The Member-Secretary,  
Chennai Metropolitan  
Development Authority,  
No.1, Gandhi-Irwin Road,  
Egmore, Chennai-600 008.

Letter No. B1/29098/2005.

Sub: CMDA - Area Plans Unit - Planning

Permission - Proposed Construction of 5/11 part of floor +  
4 floors residential building with 50 dwelling units at S.No. 405/8A7A2  
of Okkiam Shunajpakkam village, Plot nos: 4 to 17, CMDA  
Mount P.V., Tambaram Taluk, Kanchipuram District. Remittance  
Appdt. No. 123/88, St. Thomas

AREA STATEMENT

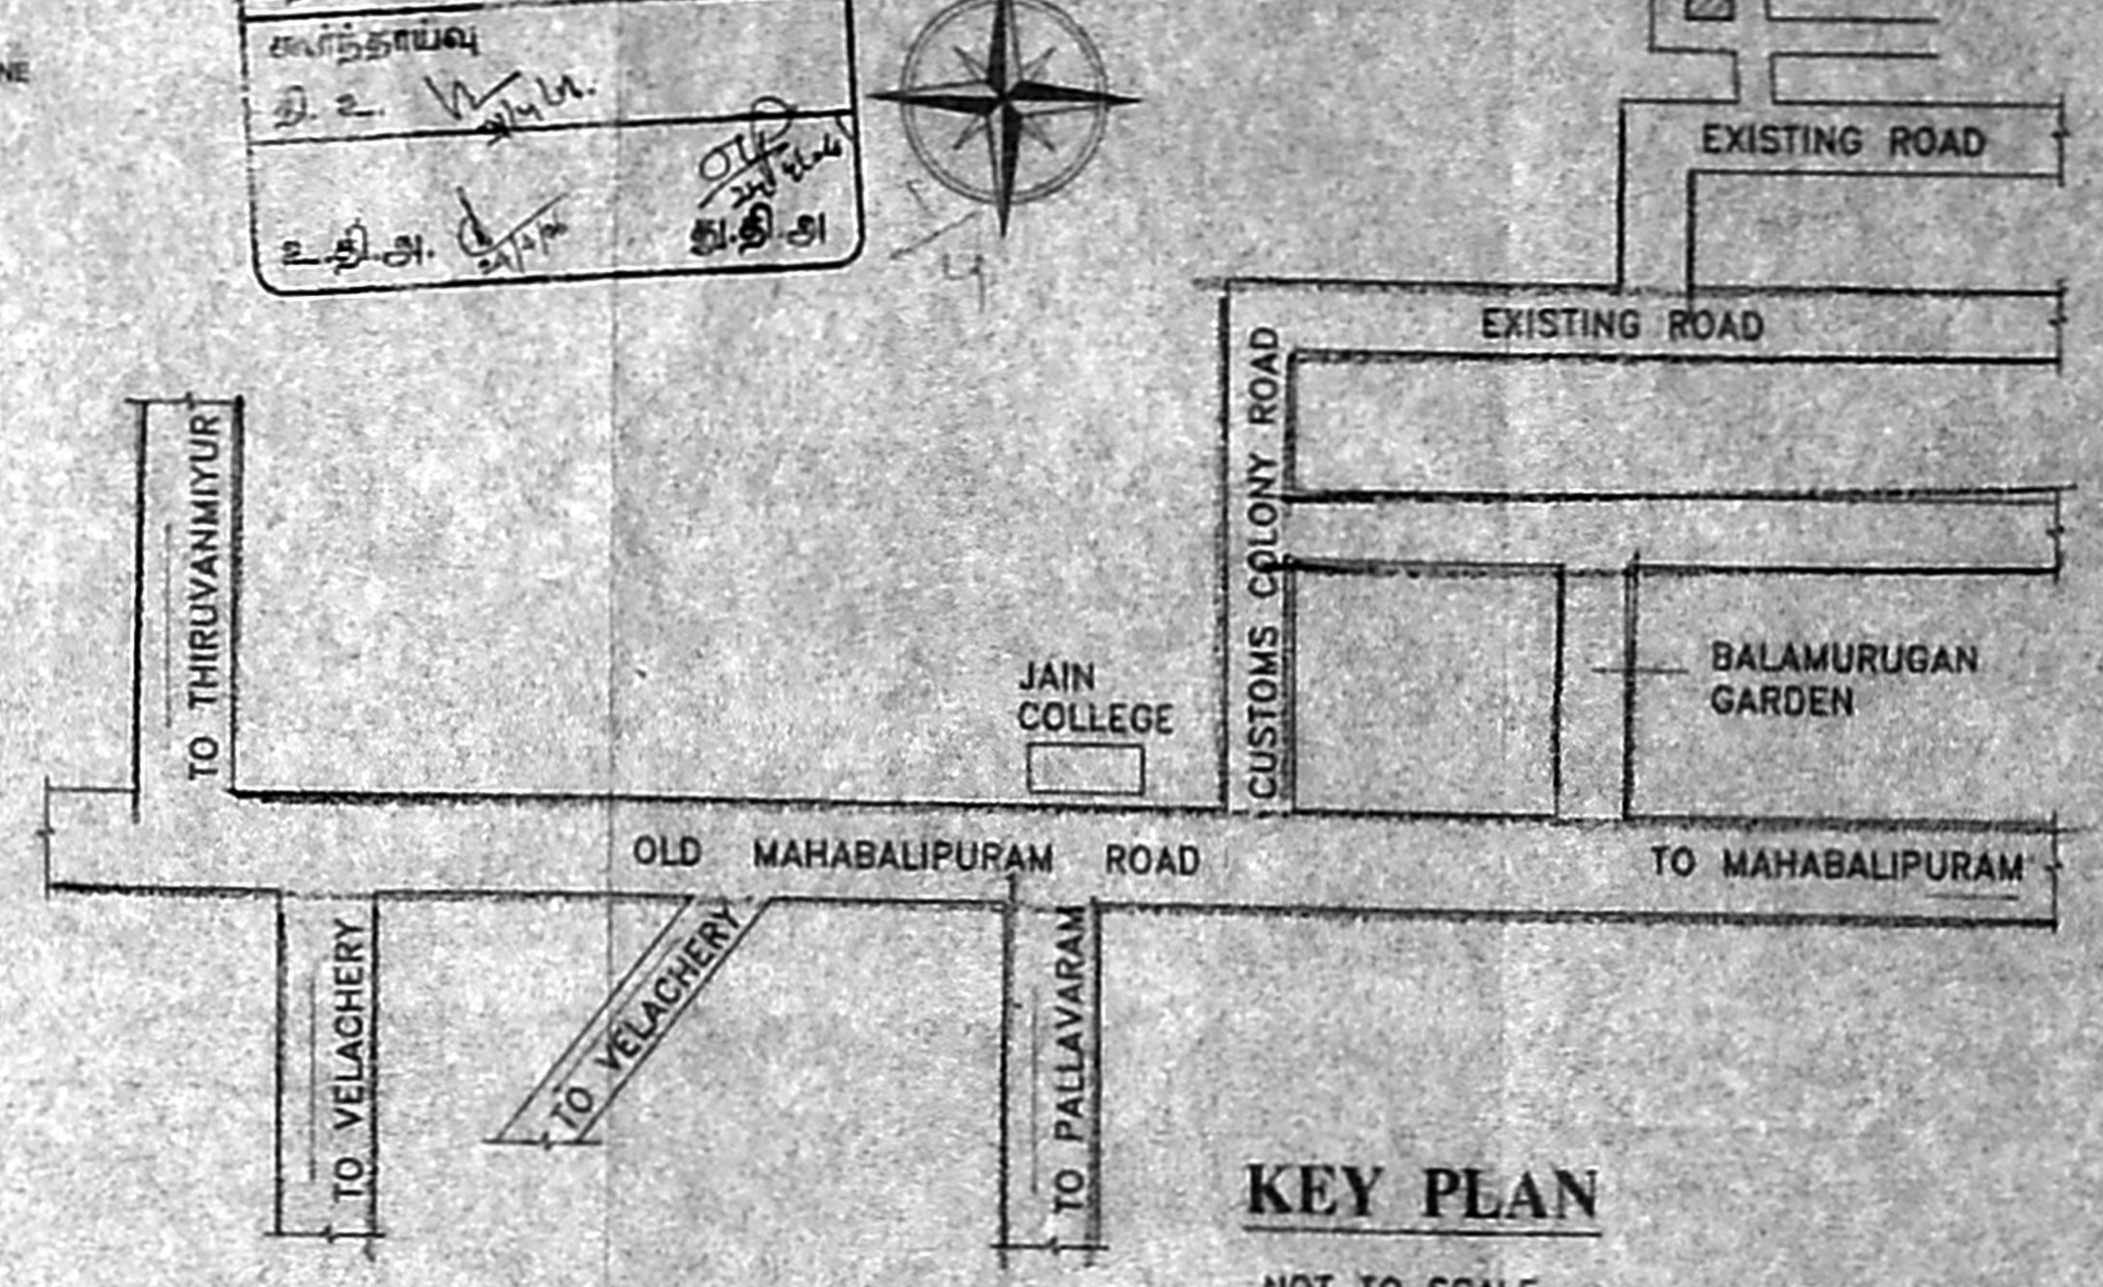
- a) 5 sets of revised plans rectifying the following defects:
  - i) Area Statement needs correction.
  - ii) In the STP plans title <sup>Contractors and</sup> the Tambaram Taluk to be incorporated.
- b) Clear copy of sketch annexed with the Sale doc no: 6580 of 2004, duly attested by a notary public.
